WEST SUSSEX COUNTY COUNCIL CONSULTATION

TO:	Arun District Council FAO: Simon Davis
FROM:	WSCC - Highways Authority
DATE:	29 July 2021
LOCATION:	The Croft Surgery Barnham Road Chichester PO20 3RP
SUBJECT:	BN/62/21/PL Medical centre with pharmacy retail unit & other ancillary uses together with access onto Barnham Road, associated car parking and other hard and soft landscaping works. This site is in CIL zone 2 (Zero Rated) as other development. Transport Assessment, Travel Plan, Road Safety Audit, Designers Response & Access Plan amendments have been received.
DATE OF SITE VISIT:	n/a
RECOMMENDATION:	Advice
S106 CONTRIBUTION TOTAL:	n/a

PROPOSED SITE PLAN

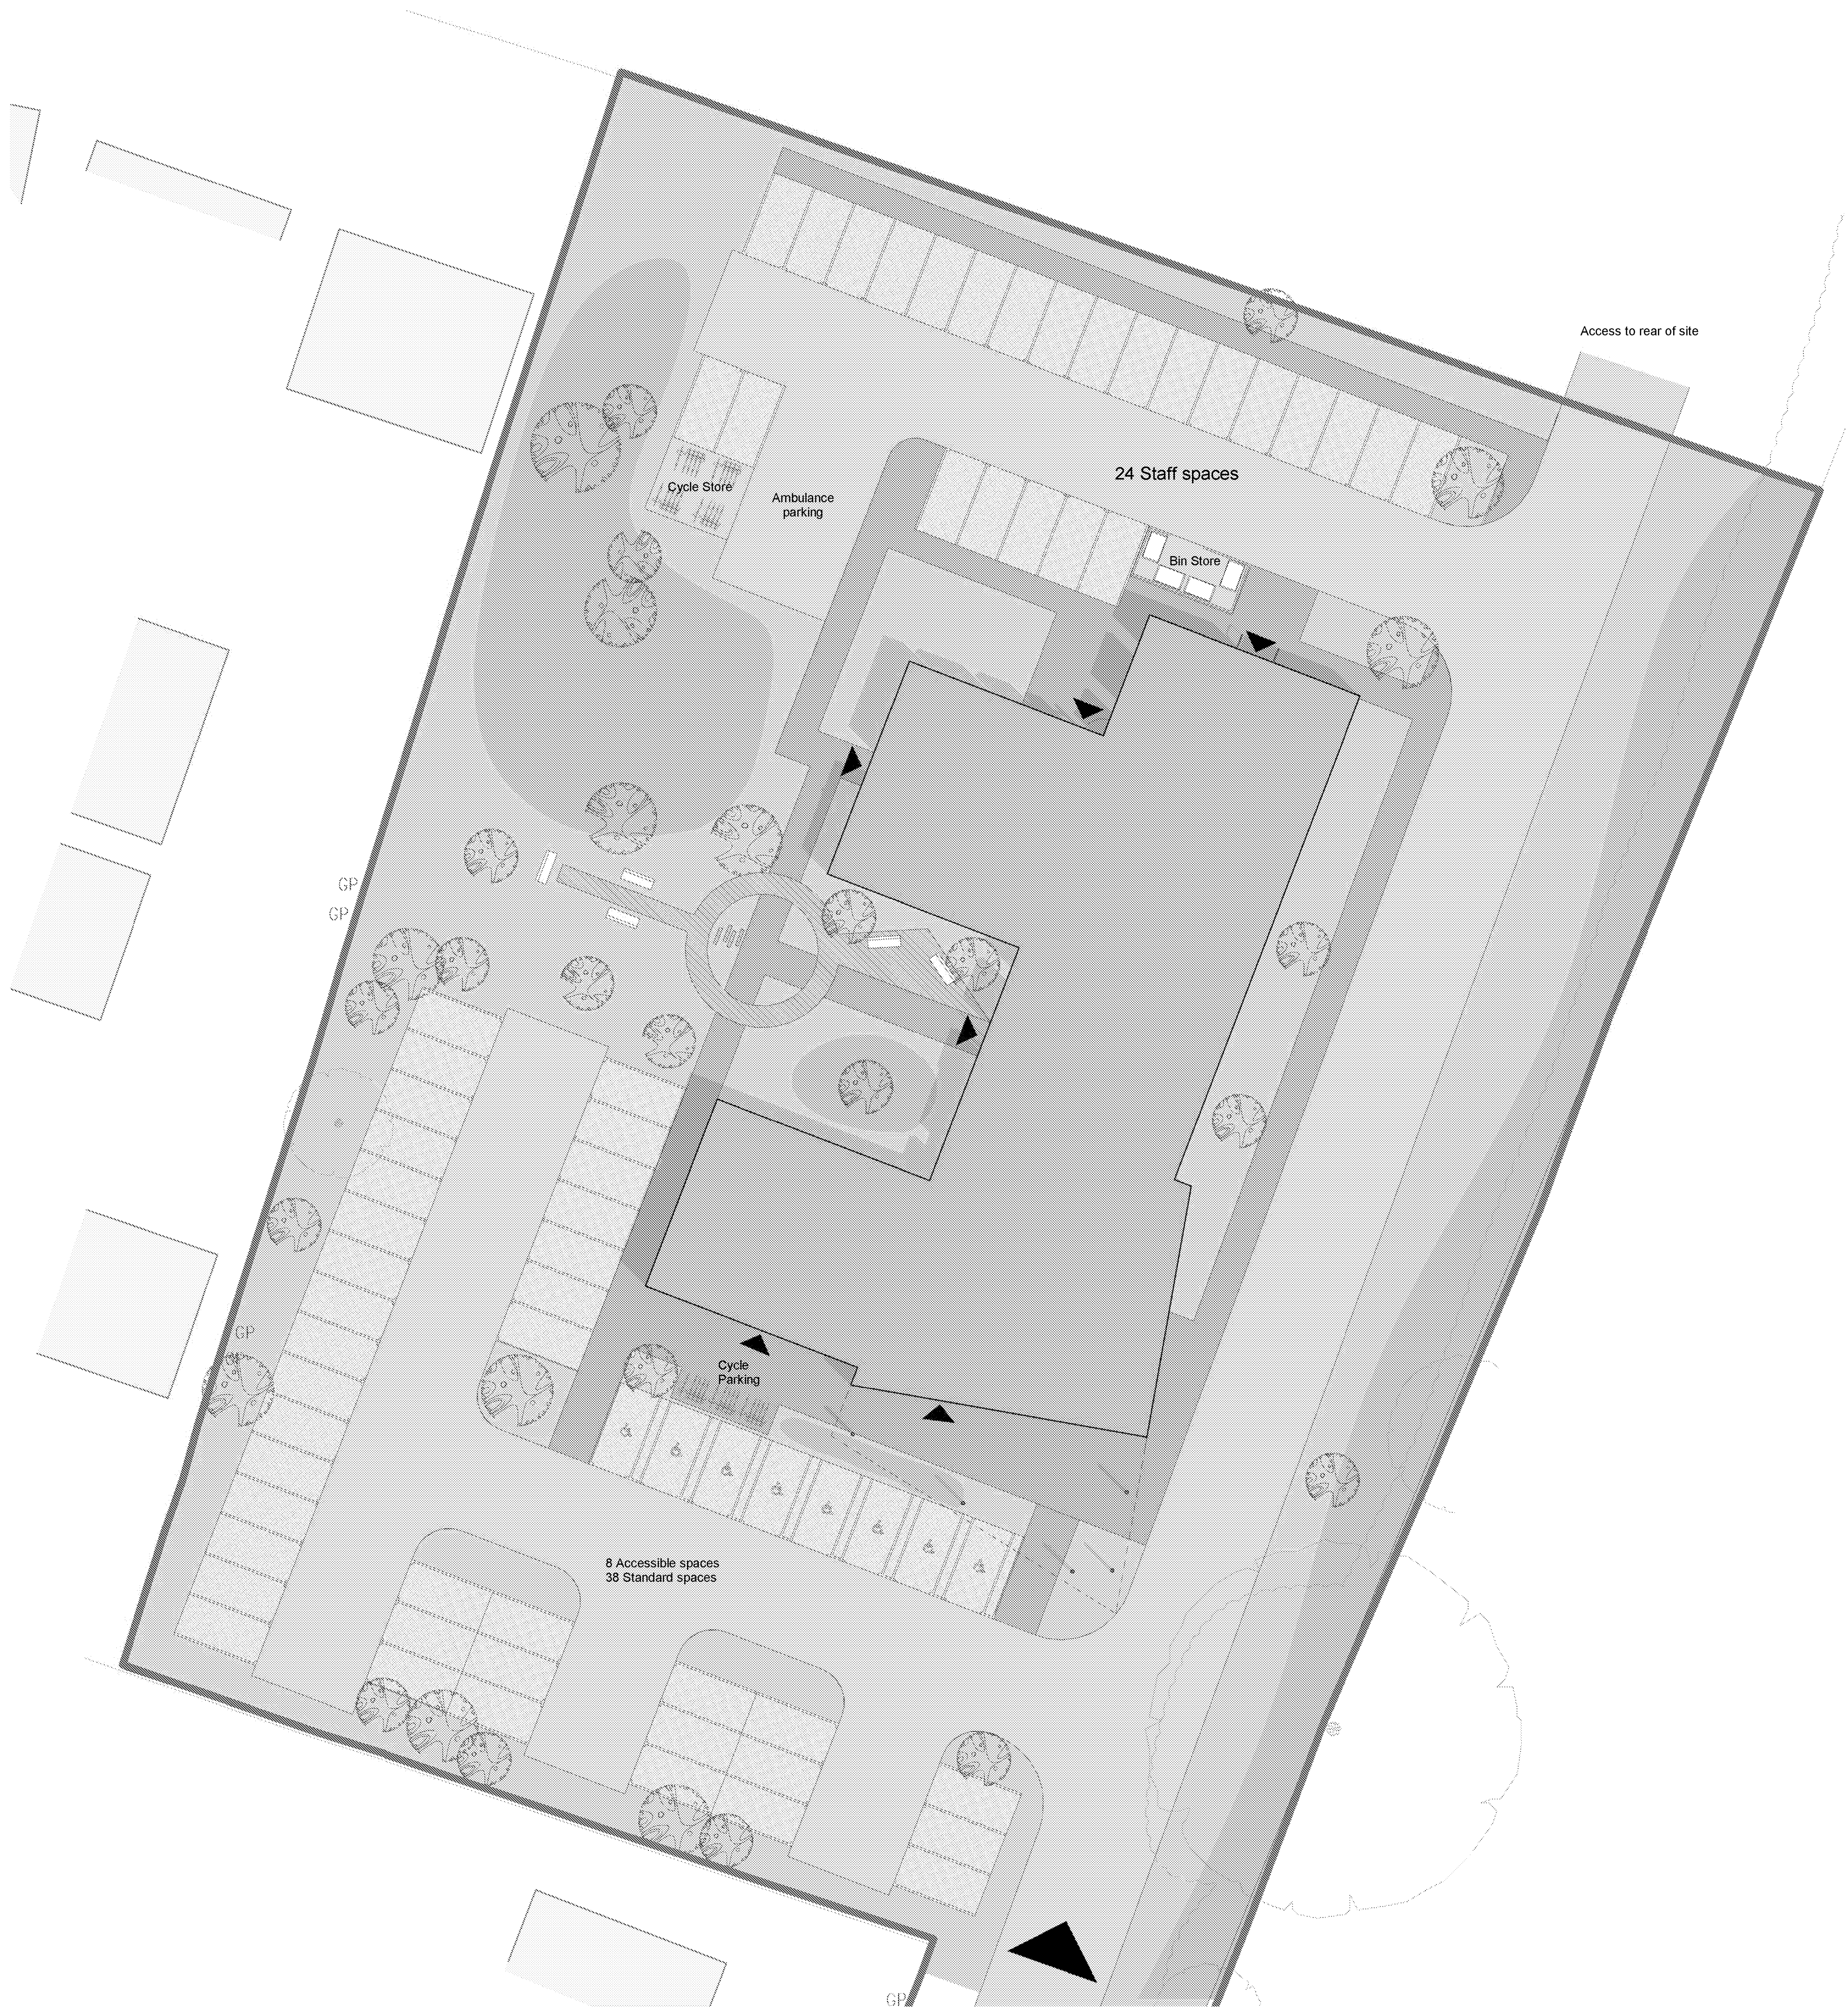
The proposed plan demonstrates 28 staff parking spaces and 44 patient spaces, including 8 accessible bays. Two additional drop off bays will be provided, one for taxis and one for ambulances. The level of parking provision is considered to be acceptable given the site's location and that many patients will visit on foot. Each space appears to meet minimum specifications of 2.4 x 4.8m as set out in Manual for Streets and each space appears to have sufficient clearance to enable vehicles to turn on site and exit in a forward gear.

No part of the development shall be first occupied until the car parking has been constructed in accordance with the approved site plan. These spaces shall thereafter be retained at all times for their designated purpose.

Project: The Croft Medical Centre		
Title: Proposed Access Arrangement and Visibility Splays		
Scale: 1:250 (@ A3)		
Notes:		Revision: A
Drawing: 2011094-01

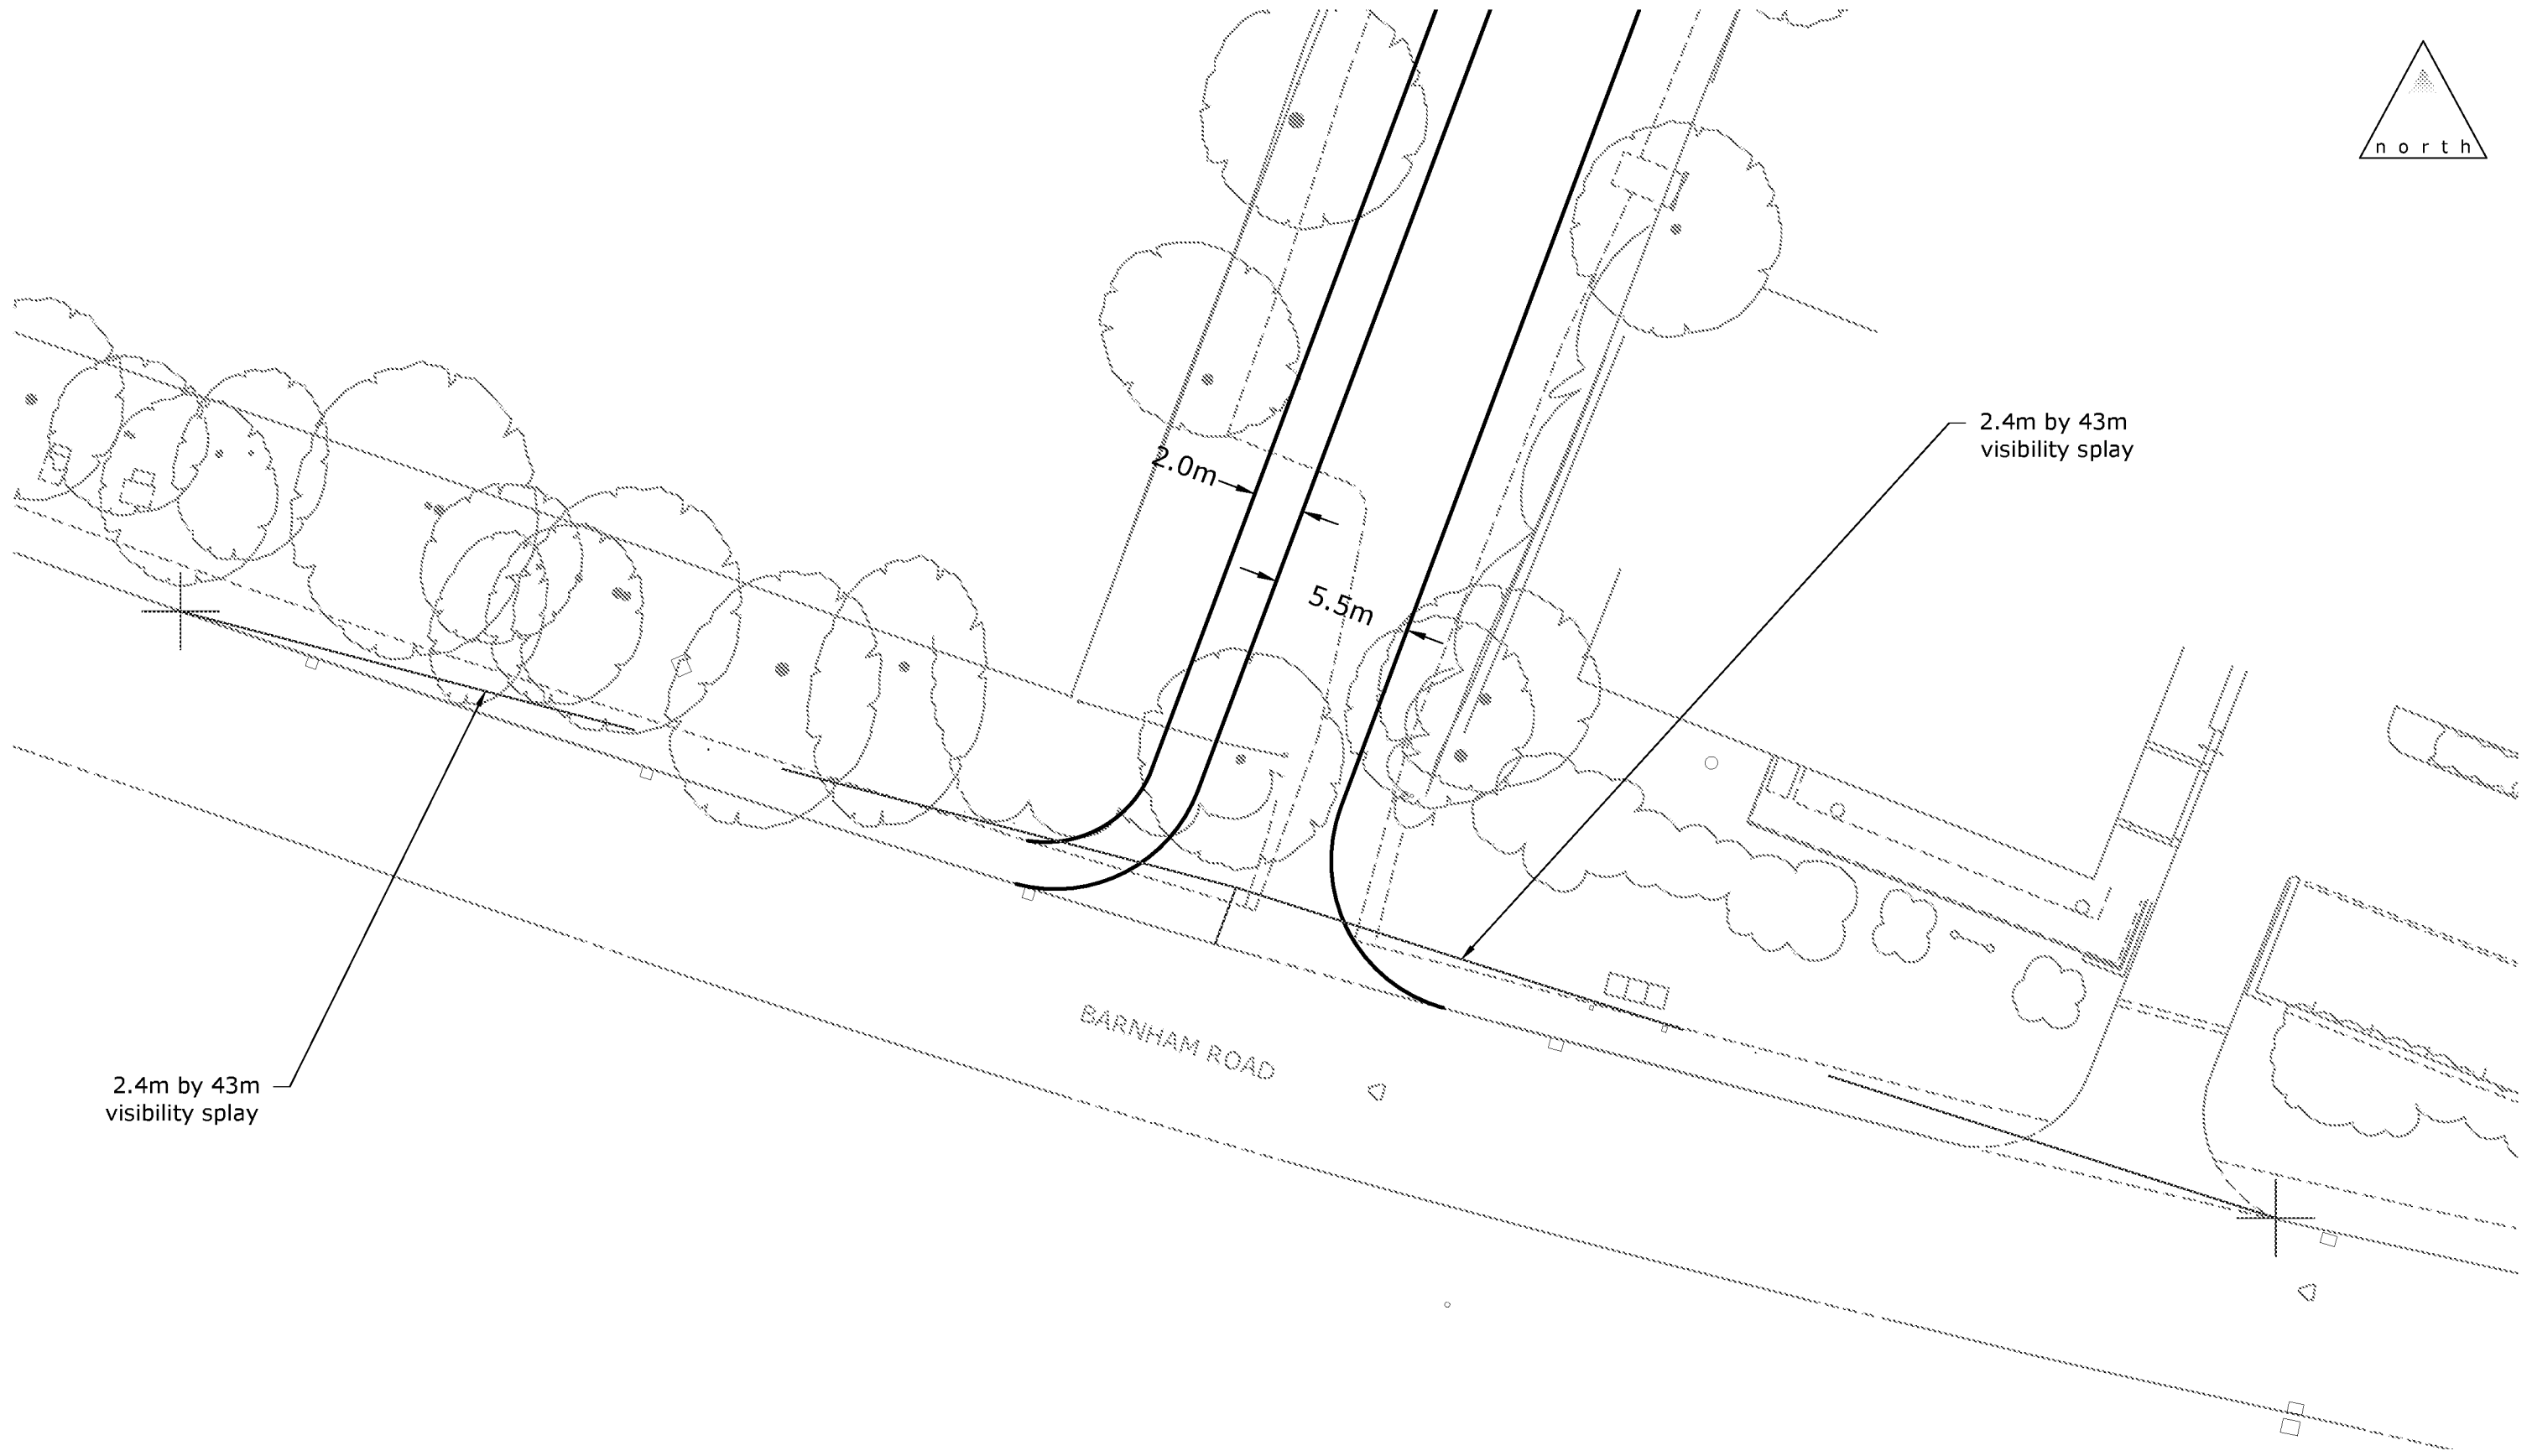
The proposed plans demonstrate that the existing access, currently serving the staff parking area will be utilised for the proposed new medical centre. The plans indicate that the access will be widened and take the form of a 6m bell-mouth radii access, approximately 15m wide at the carriageway edge, with an internal width of 5.5m. This would be sufficient for two vehicles to pass within the access and within the internal access-way. A 2m wide footway is also proposed on the western side of the access, connecting the site to the existing western footway. The proposed access works would be subject to a Section 278 agreement with the WSCC Implementation Team, and an informative is advised below.

Appendix B of the Transport Statement demonstrates visibility splays of 43m in each direction from a 2.4m setback within the proposed access, which is in accordance Manual for Streets for a 30mph road.

No part of the development shall be first occupied until such time as the vehicular access serving the development has been constructed in accordance with the details shown on the drawing titled Proposed Access Arrangement and Visibility Splays and numbered 2011094-01 Rev C.

No part of the development shall be first occupied until visibility splays of 2.4 metres by 43 metres have been provided at the proposed site vehicular access onto Barnham Road in accordance with the approved planning drawings. Once provided the splays shall thereafter be maintained and kept free of all obstructions over a height of 0.6 metre above adjoining carriageway level or as otherwise agreed.
